# CITY OF ALBUQUERQUE

March 30, 2020

**Re: Paleta Bar/Spring Roll Restaurant**  
**317 Gold Ave. SW**  
**Traffic Circulation Layout**  
Architect's Stamp 03-27-20 (H14-D223)

SITE PLAN / TRAFFIC CIRCULATION LAYOUT

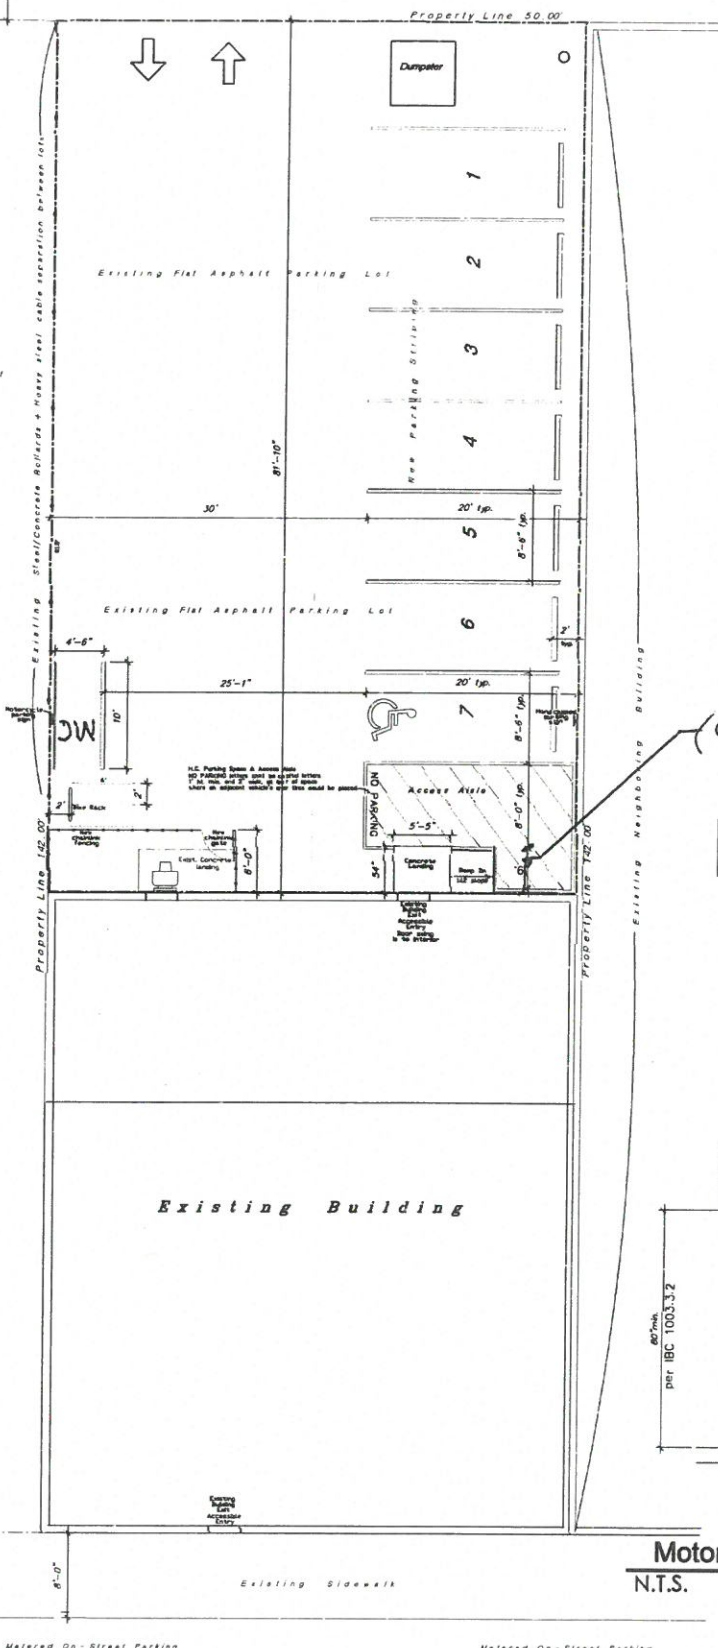
1. Please coordinate all calculations for parking spaces, including bicycle, and motorcycle parking with Zoning and list the number of parking spaces required by the zoning code as well as the proposed number of parking spaces including bicycle and motorcycle parking.
2. Please identify all existing buildings, doors, structures, sidewalks, curbs, drive pads, wall and anything that influences the parking and circulation on the site.
3. Identify all existing access easements and rights of way width dimensions.
4. Please list the width and length for all existing and proposed parking spaces. Some dimensions are not shown. The minimum parking stall dimensions are:

5. The ADA accessible parking sign must have the required language per 66-7-352.4C NMSA 1978 **"Violators Are Subject to a Fine and/or Towing."** Please call out detail and location of signs.
6. ADA curb ramps must be updated to current standards and have truncated domes installed ( corner of Gold and 4<sup>th</sup>, **IF APPLICABLE**)
7. Motorcycle parking spaces shall be designated by its own conspicuously posted upright sign, either free-standing or wall mounted per the zoning code.

12. Per the IDO, a 6 ft. wide ADA accessible pedestrian pathway is required from the public sidewalk to the building entrances. Please clearly show this pathway and provide details.

13. Per DPM, a 6 ft. wide ADA accessible pedestrian pathway is required from the ADA parking stall access aisles to the building entrances. Please clearly show this pathway and provide details.

14. Curbing should be installed to delineate landscape, parking, and pedestrian ways, **PROPERTY LINE(to adjacent lot)**, and identify points of access. Please call out detail and location of barrier curb.

15. Refuse vehicle maneuvering shall be contained on-site. The refuse vehicle shall not back into the public right of way.; provide a copy of refuse approval.

16. It is not apparent what type of pavement surface is being proposed ADA stalls need to be 2% cross slope in all directions). A hard driving surface will be required as part of this proposed project.

17. Please provide a sight distance exhibit..
18. Show the clear sight triangle and add the following note to the plan:  
"Landscaping and signage will not interfere with clear sight requirements. Therefore, signs, walls, trees, and shrubbery between 3 and 8 feet tall (as measured from the gutter pan) will not be acceptable in the clear sight triangle.
19. Please specify the City Standard Drawing Number when applicable.
20. Shared Site acces: driveways that straddle property lines, or are entirely on one propertybut are to be used by another property, shall have an access easement. Please include a copy of your shared access agreement with the

21. **(IF APPLICABLE):** Unused curb cuts must be replaced with sidewalk and curb & gutter. A build note must be provided referring to the appropriate City Standard drawing.
22. Add a note stating "All broken or cracked sidewalk must be replaced with sidewalk and curb & gutter." A build note must be provided referring to the appropriate City Standard drawing.
23. Parking **SHALL NOT BE ALLOWED** in allowed in alleyway from properties.

BICYCLE RACK
N.T.S.

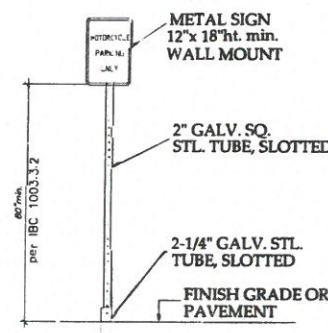
8. All bicycle racks shall be designed according to the following guidelines:
  - a. The rack shall be a minimum 30 inches tall and 18 inches wide.
  - b. The bicycle frame shall be supported horizontally at two or more places. Comb/toaster racks are not allowed.

- c. The rack shall be designed to support the bicycle in an upright position. See the IDO for additional information.
  - d. The rack allows varying bicycle frame sizes and styles to be attached.

- e. The user is not required to lift the bicycle onto the bicycle rack.
  - f. Each bicycle parking space is accessible without moving another bicycle.

9. Bicycle racks shall be sturdy and anchored to a concrete pad.
10. A 1-foot clear zone around the bicycle parking stall shall be provided.
11. Bicycle parking spaces shall be at least 6 feet long and 2 feet wide.
